Consultation Response from Biodiversity Officer
KC Ecology
2019/91327 Thongsbridge Mills, Miry Lane, Thongsbridge, Holmfirth, HD9 7RW
Reserved matters application pursuant to outline permission no. 2017/90207 for erection of B1 light industry
Date Responded:
24/05/2019
Responding Officer:
Tom Stephenson
Responding Ref:

Plan View

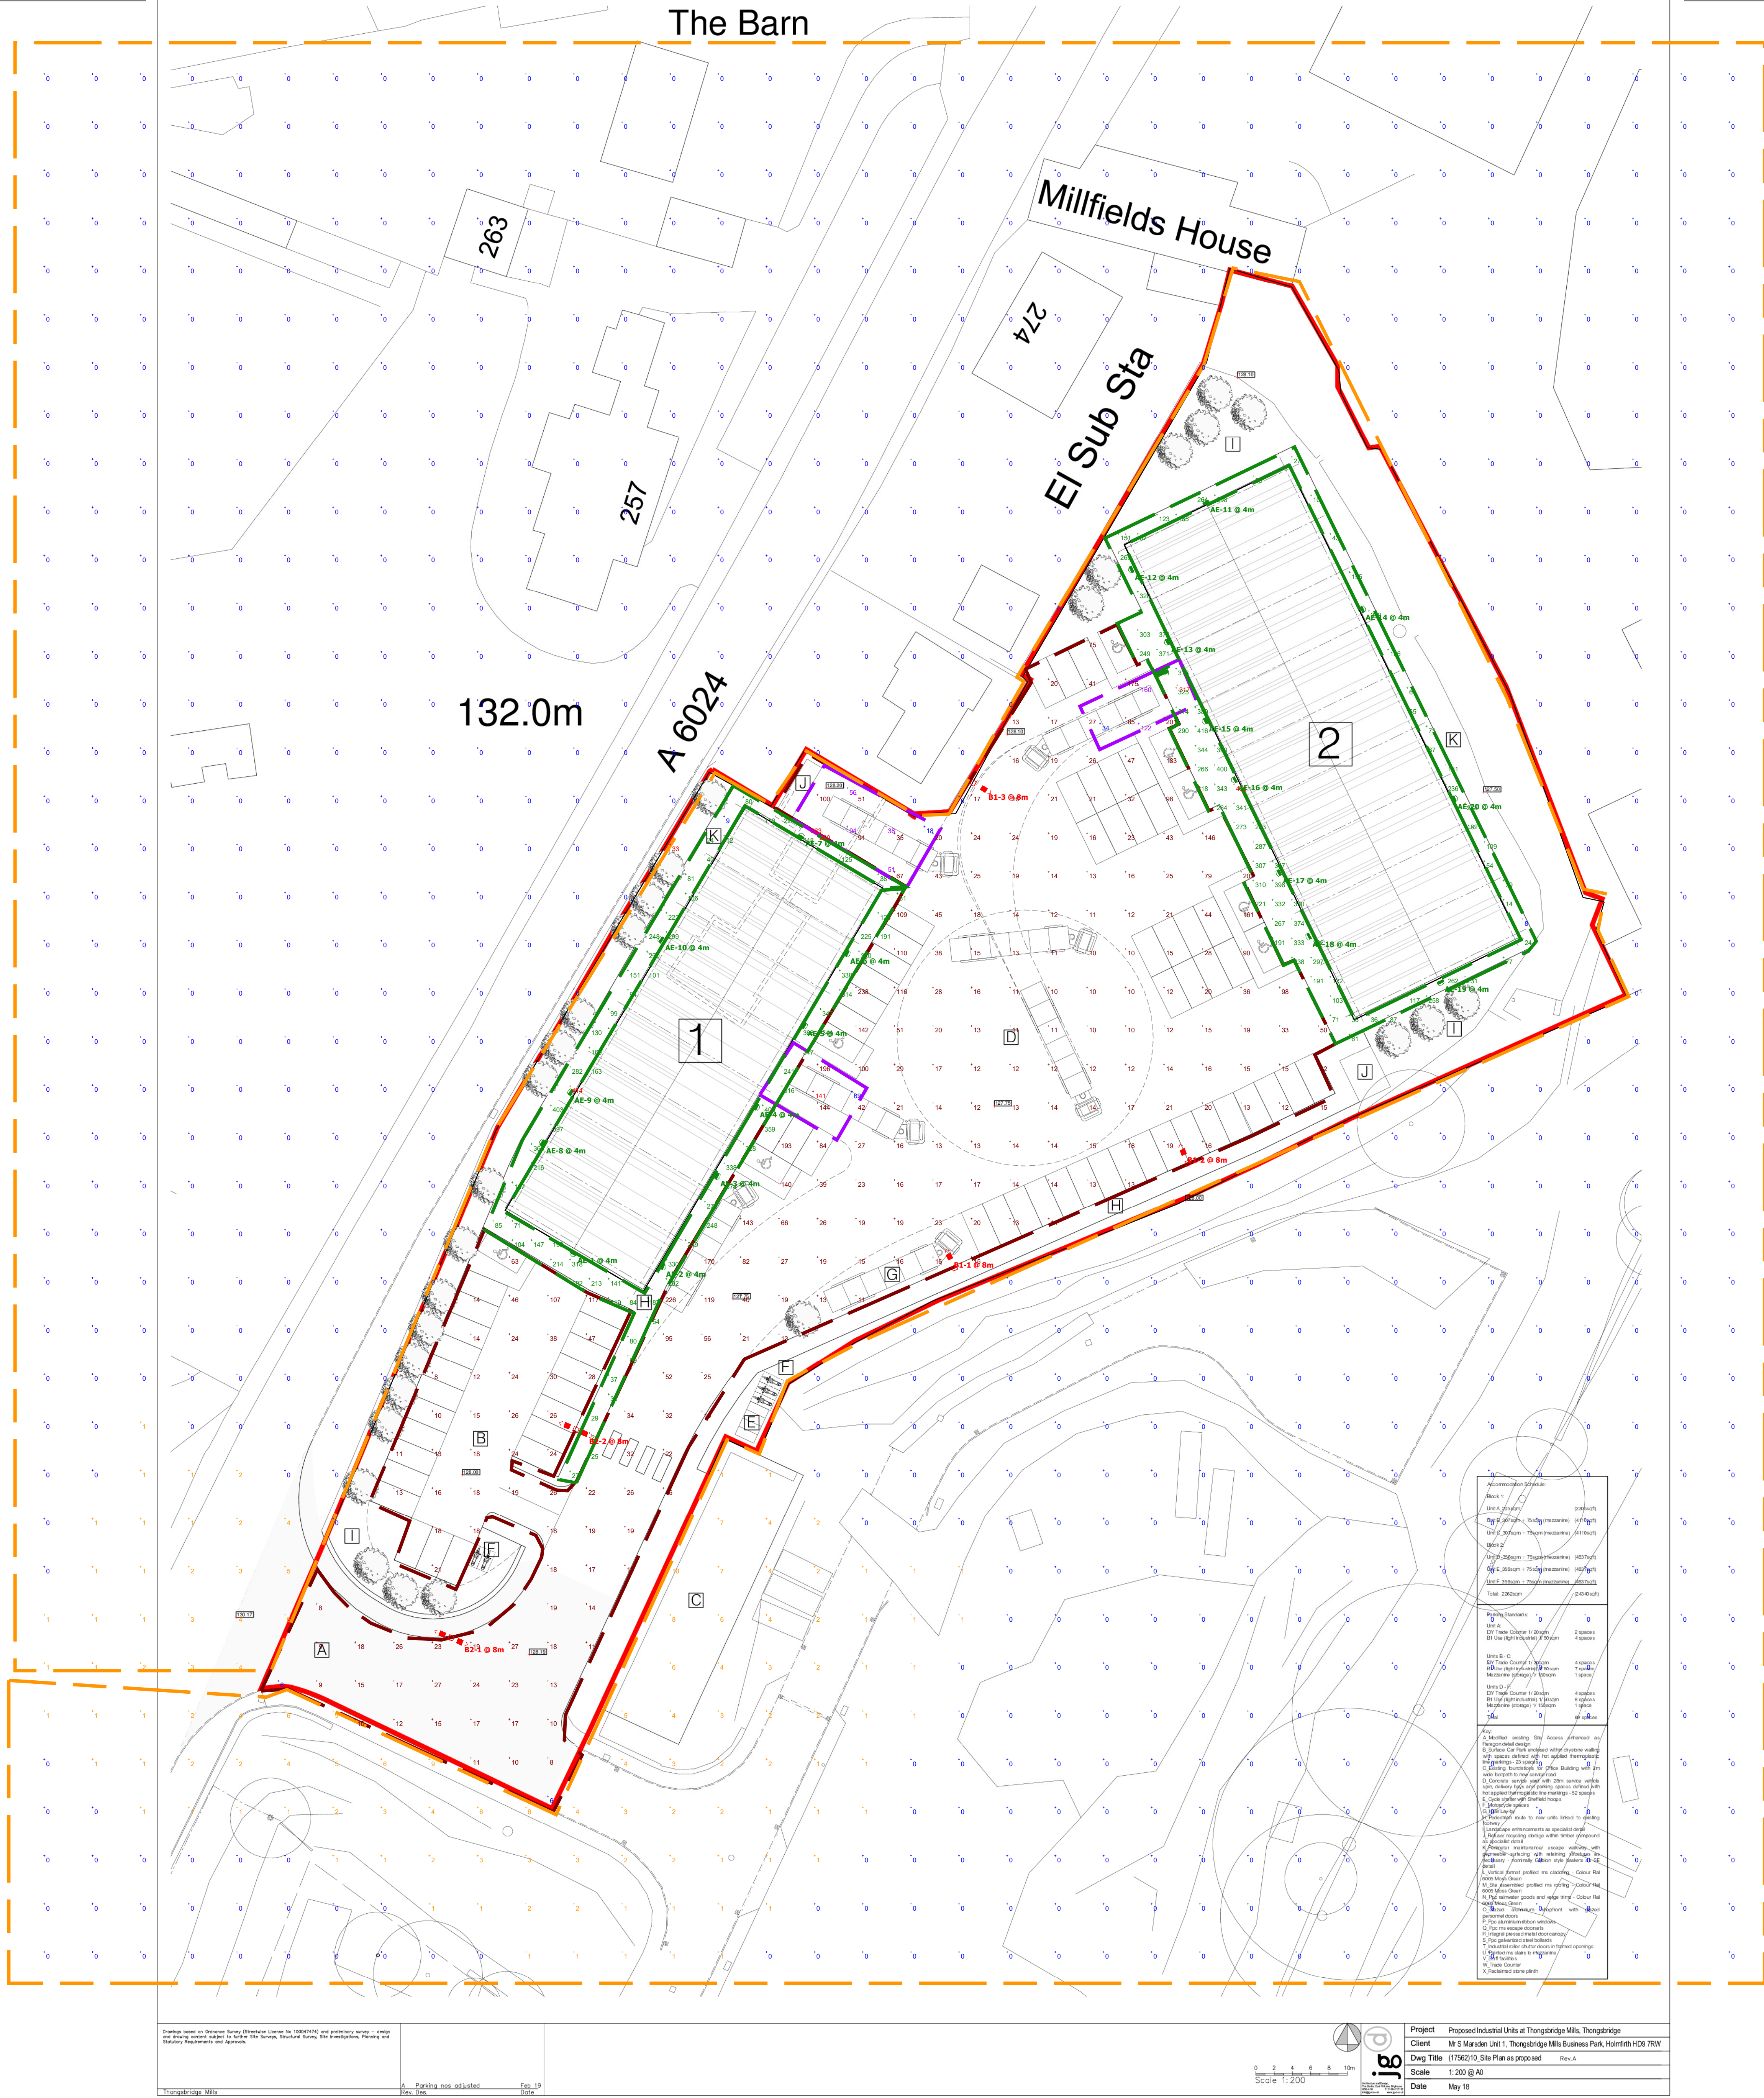
An Ecological Design Strategy (EDS) has been submitted to address condition 12 and provides details of measures to be included in the lighting design and refers to a separate lighting layout plan that is submitted in relation to condition 20. The lighting layout plan does not provide sufficient information to demonstrate that the measures described in the EDS have been incorporated. In particular, lighting levels for the area of native planting are not shown.
